NSW GOVERNMENT  
**Department of Planning**

**RE: MP 06\_0034 – 76 and 84 Greenwell Point Road, Greenwell Point and Goodnight Island off Orama Crescent, Orient Point (respectively), Proposed Mixed Use Development**

## ANNEXURE A – ISSUES

Figure 1: Dynamic wet-weather storage volumes over 50 year simulation period with no irrigation when storage tank is full.

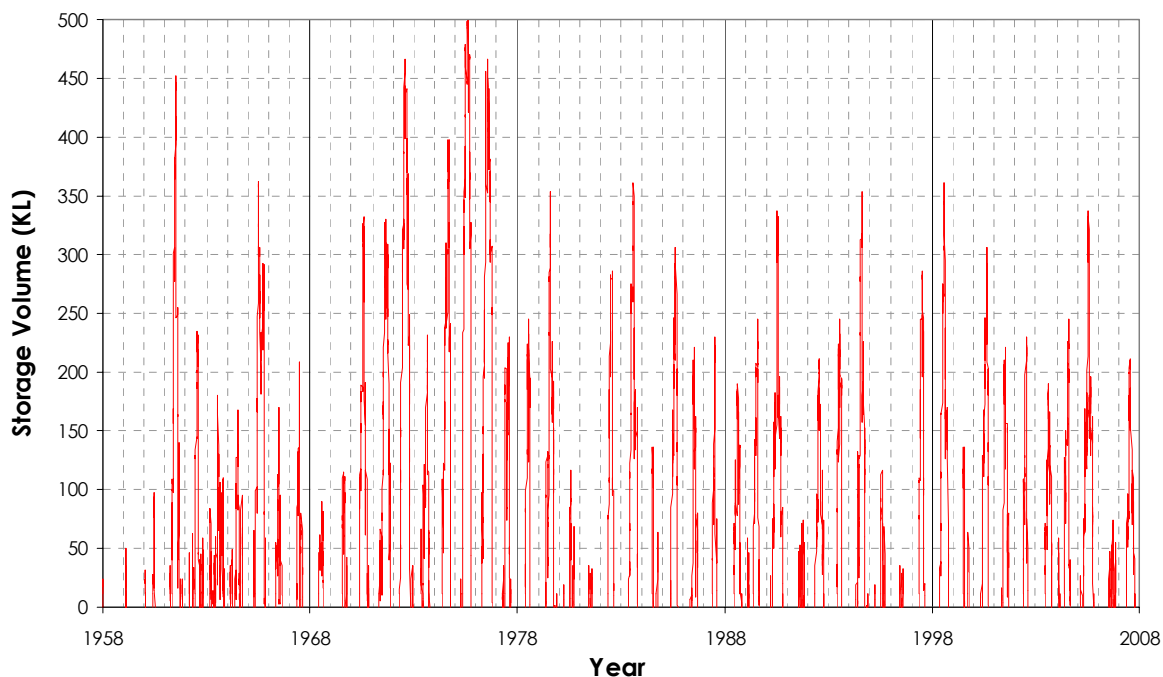
- Based on the W&A daily load designs the proposed 100KL wet weather storage is significantly undersized and would only support 4.4 days of treated effluent.

- W&A carried out a water balance using climatic data and the W&A predicted daily loads and determined that wet weather storage of 1,400KL is required for an irrigation area of 6,617m<sup>2</sup>. It might be possible to reduce the wet weather storage requirement by increasing the size of the irrigation area.

- Provide clarification on effluent disposal area and wet weather storage size based on W&A amended hydraulic loading.
- Prepare an Operation and Maintenance Management Plan for the wastewater treatment plant and its disposal area.
- Prepare a Wastewater Management Emergency Response Plan in respect to failure or accidental discharges to the waterway, taking into consideration the requirements of NSW Shellfish Program.
- Clarify the term 'storage dams' listed in Martens (2007b).
- Clarify the term 'pump out' listed in Martens (2007b) and seek clarification on how this procedure could be implemented on Goodnight Island.
